PUBLIC SUBMISSIONS

Blue indicates additional shadow

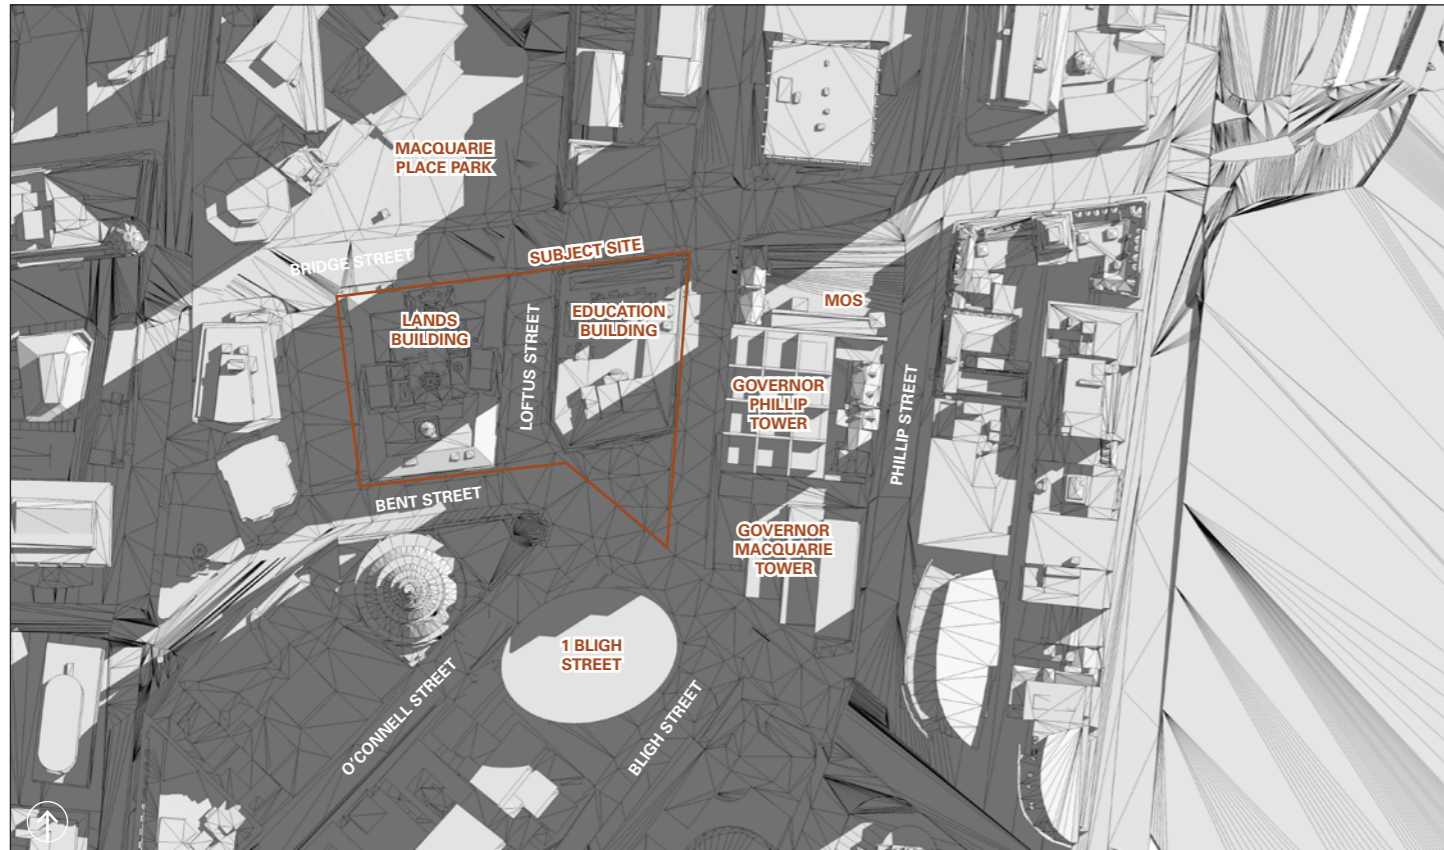
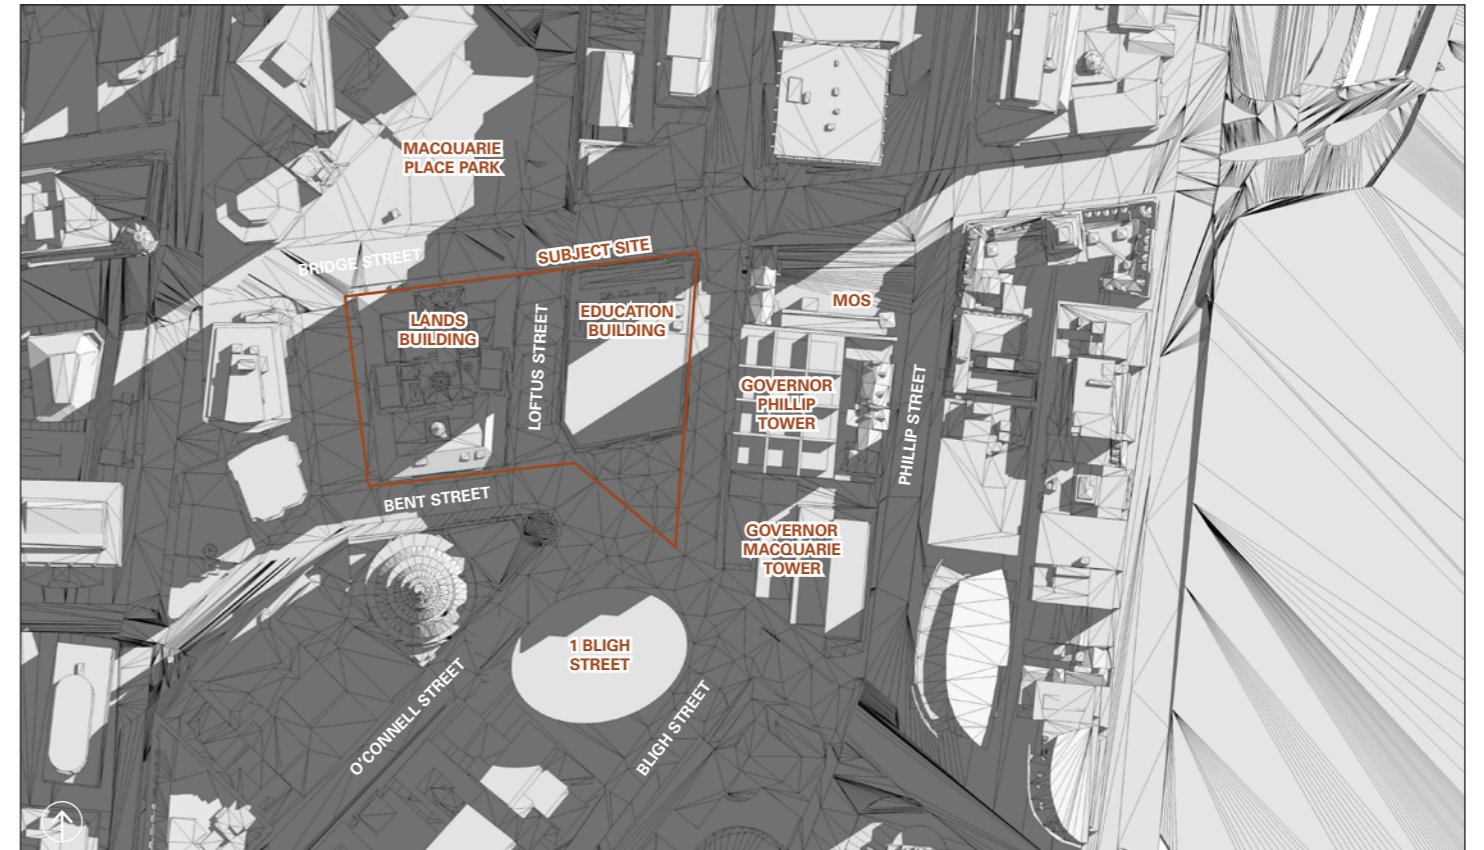
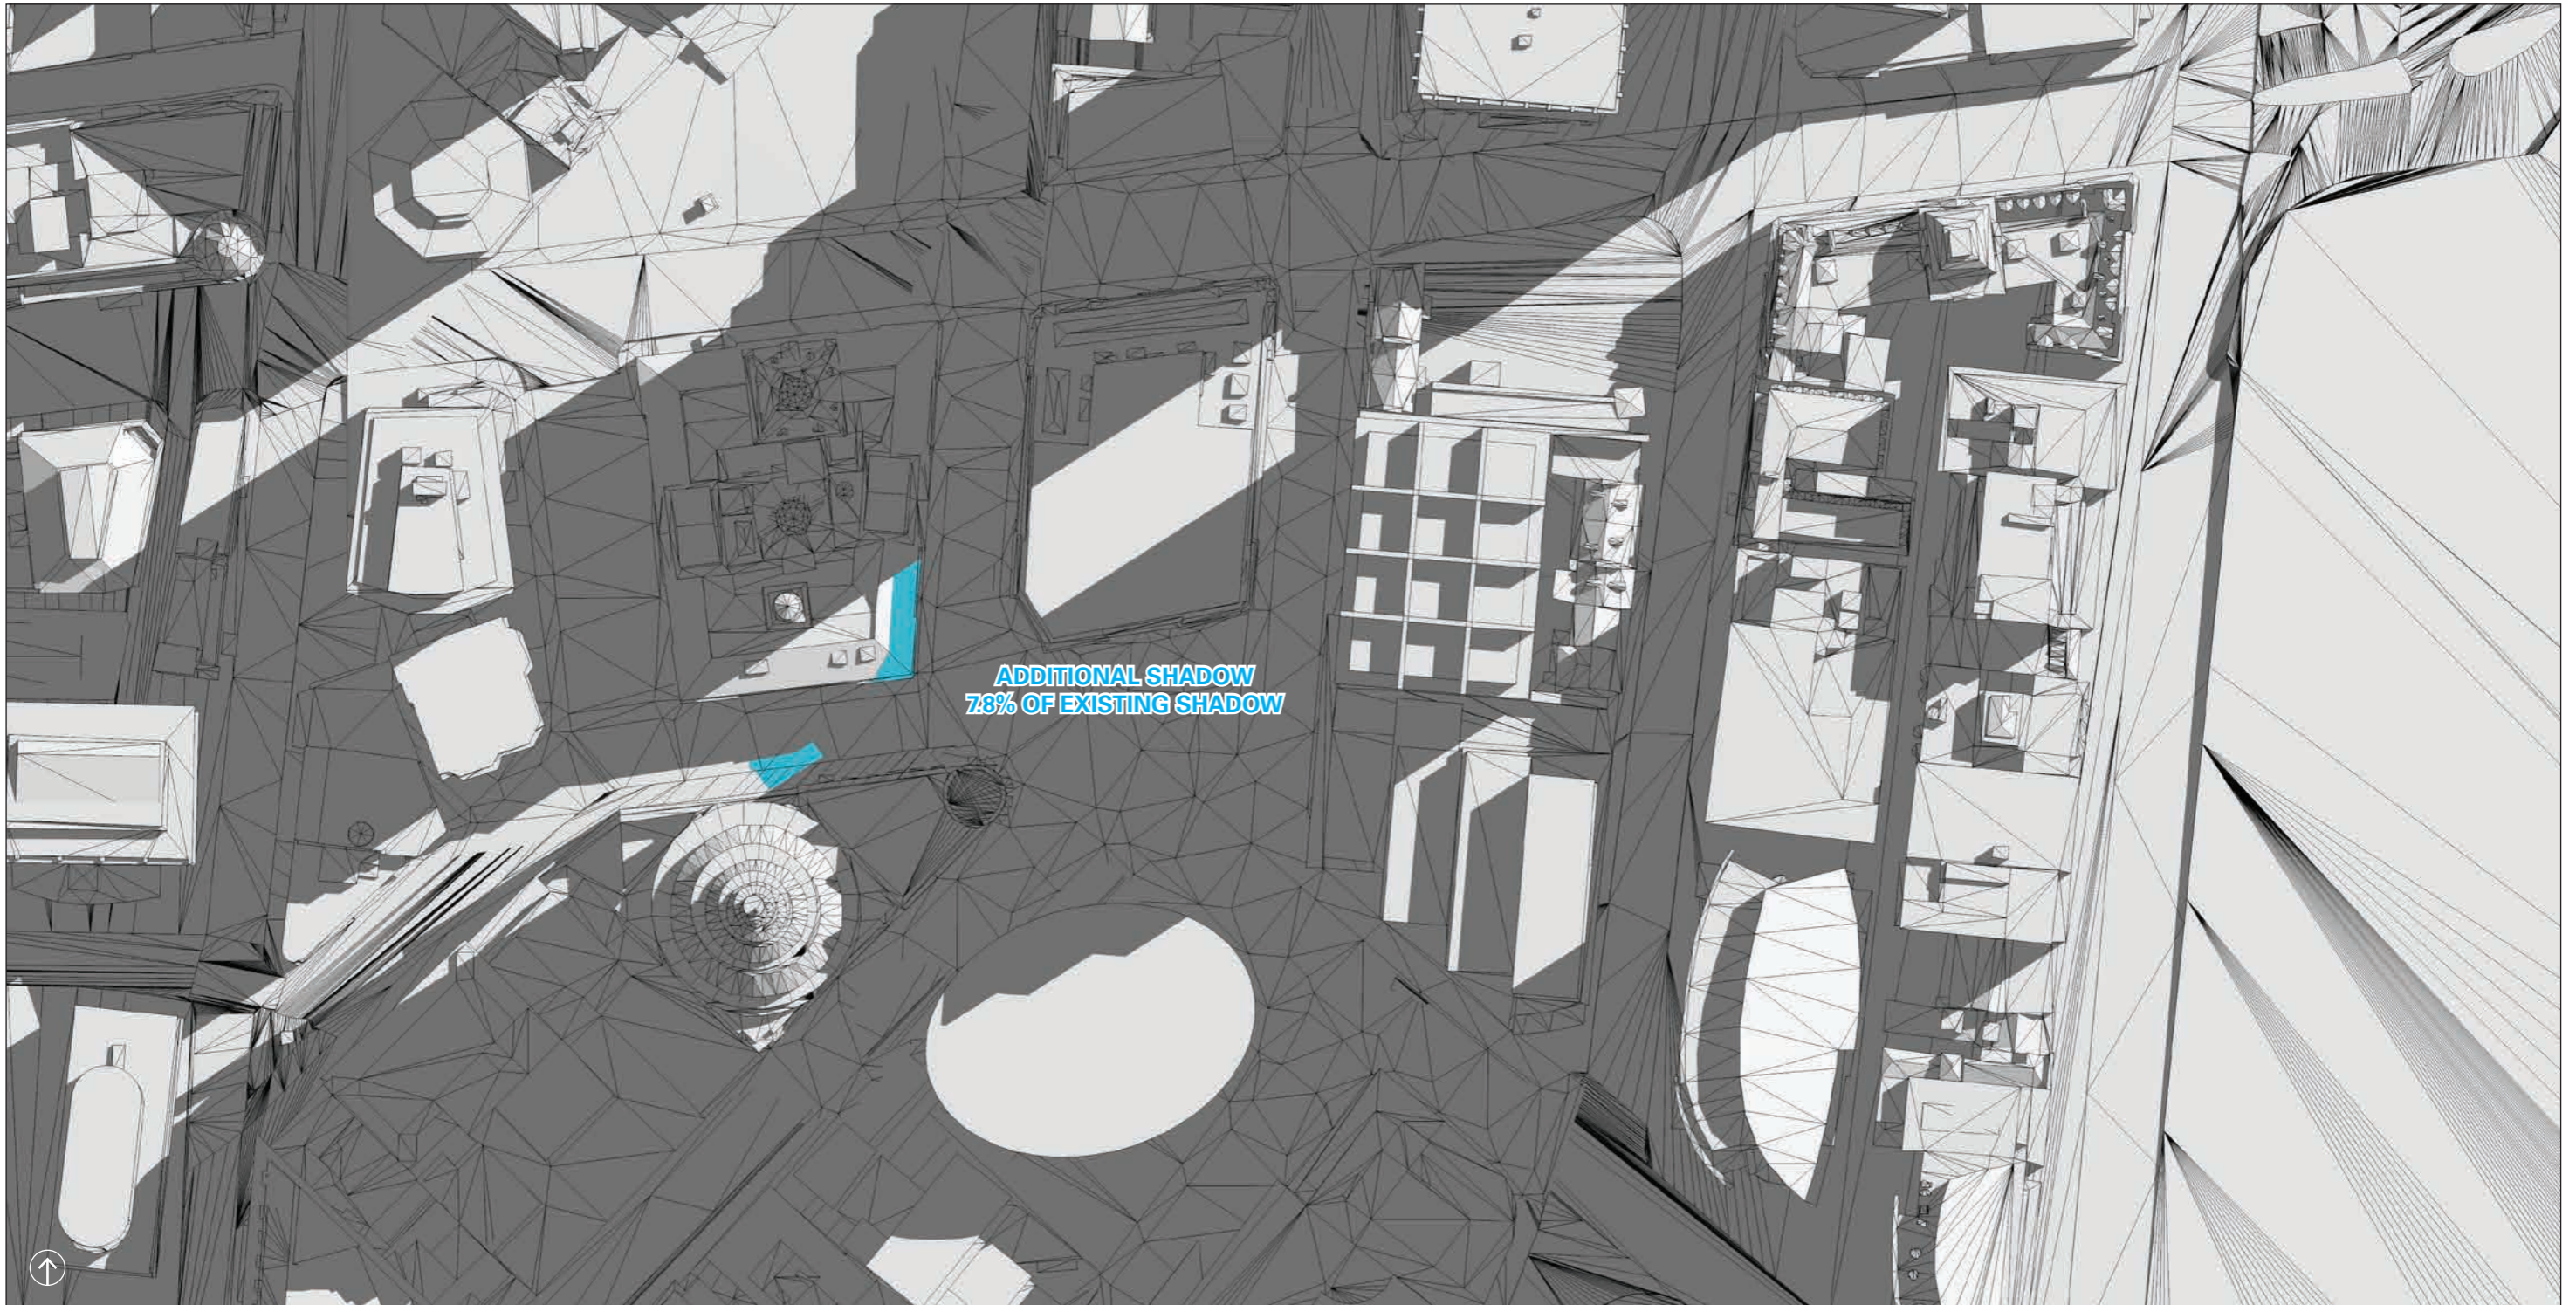
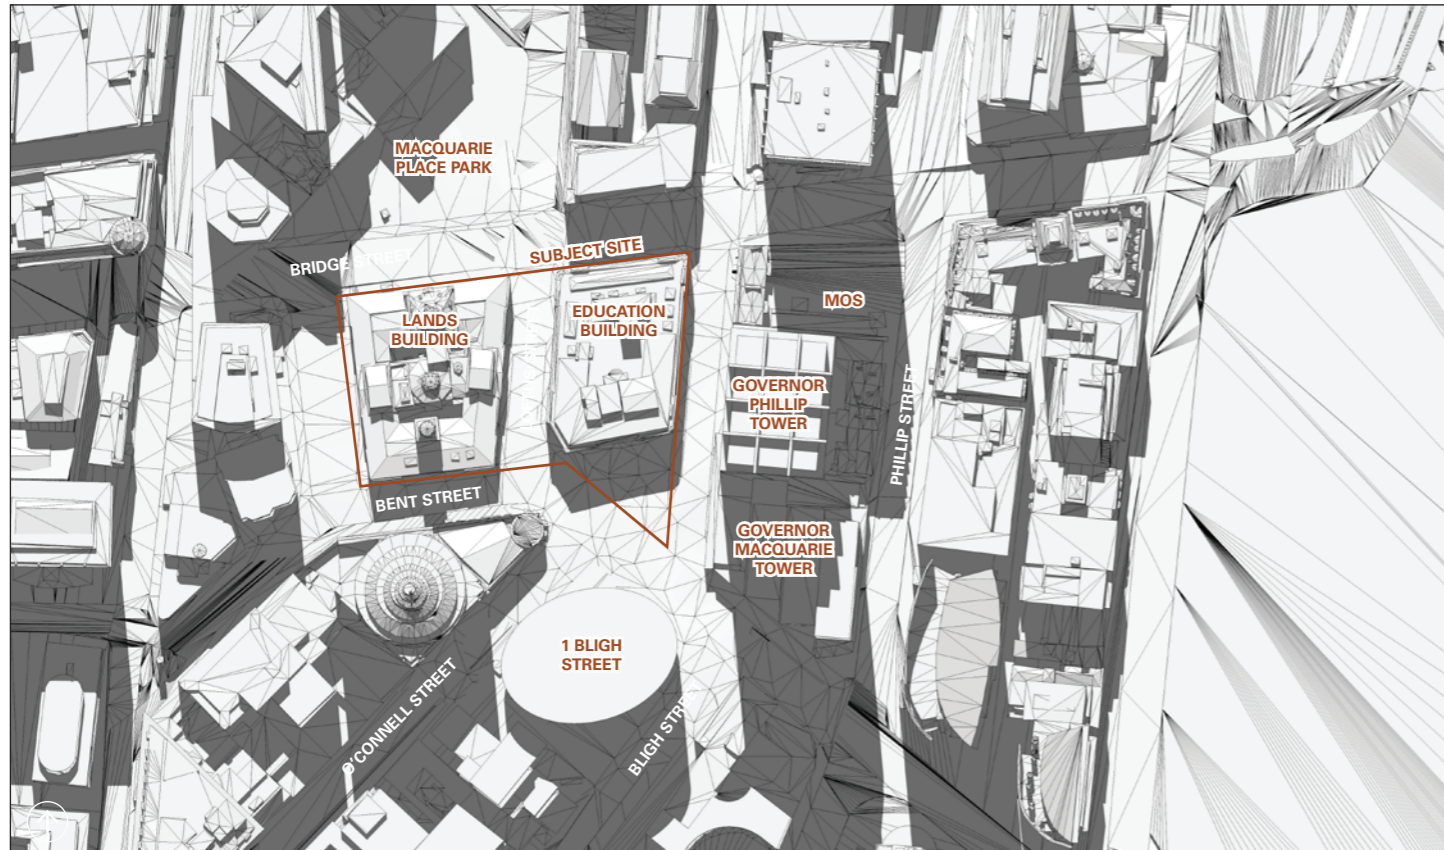
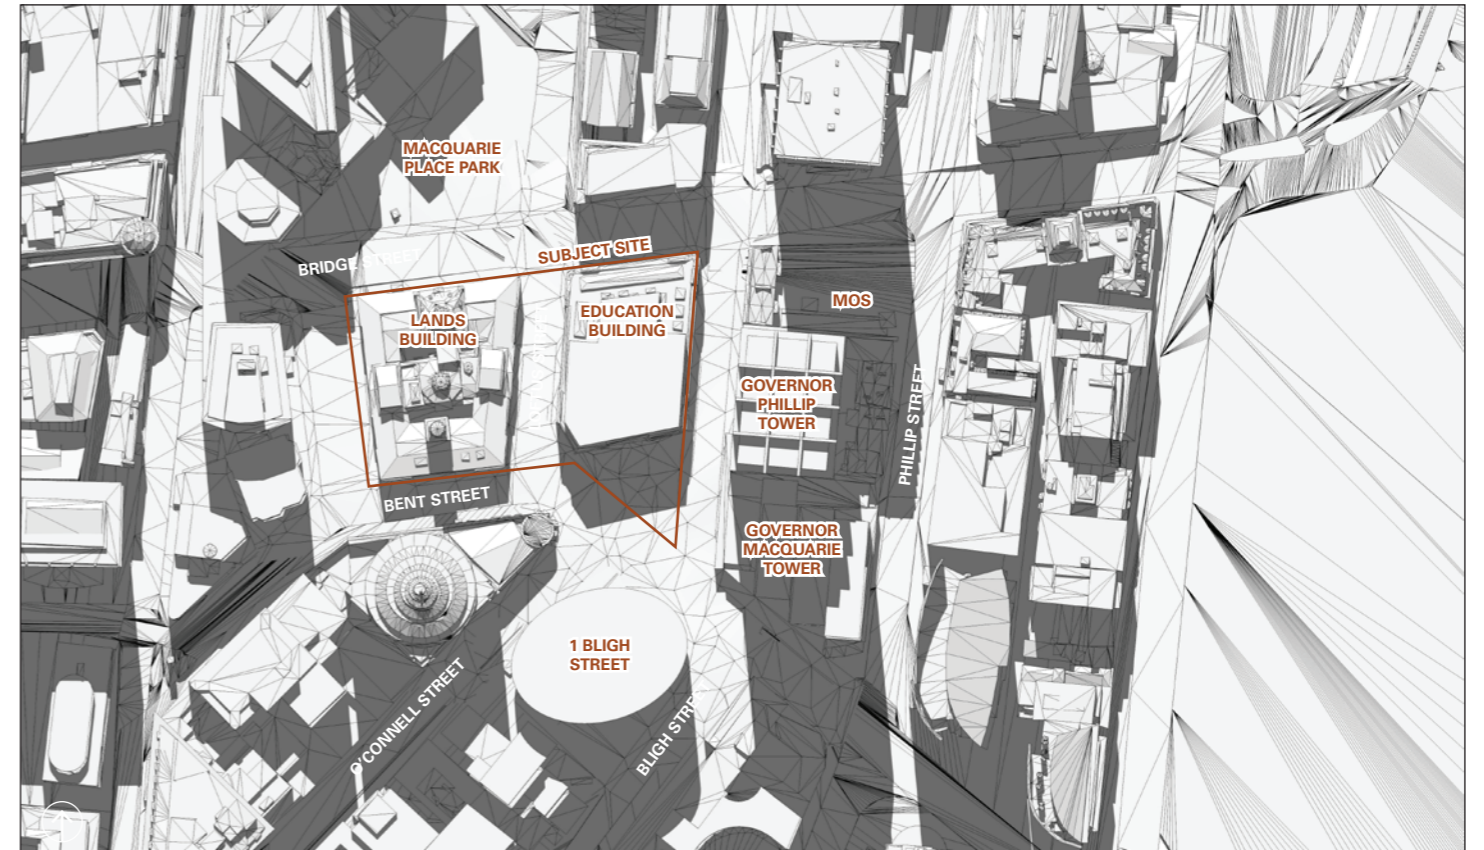
| <p>HEIGHT/OVERSHADOWING</p> <p>Increase in overshadowing</p> <p>Height increase is unacceptable when viewed from adjoining streets (should be setback)</p> <p>Rooftop additions should be setback</p> <p>The additional floors which create unacceptable shadow impacts on Farrer Place.</p> <p>The additional floors will create overshadowing on the Lands Building, which has not been addressed.</p> | <p>6</p> | <p>Clive Gunton</p> <p>Philip Drew</p> <p>WITHHELD</p> <p>WITHHELD</p> <p>John Freeman</p> <p>Peter Webber</p> | <p>See Section 2.1 of the Response to Submissions (RTS).</p> |
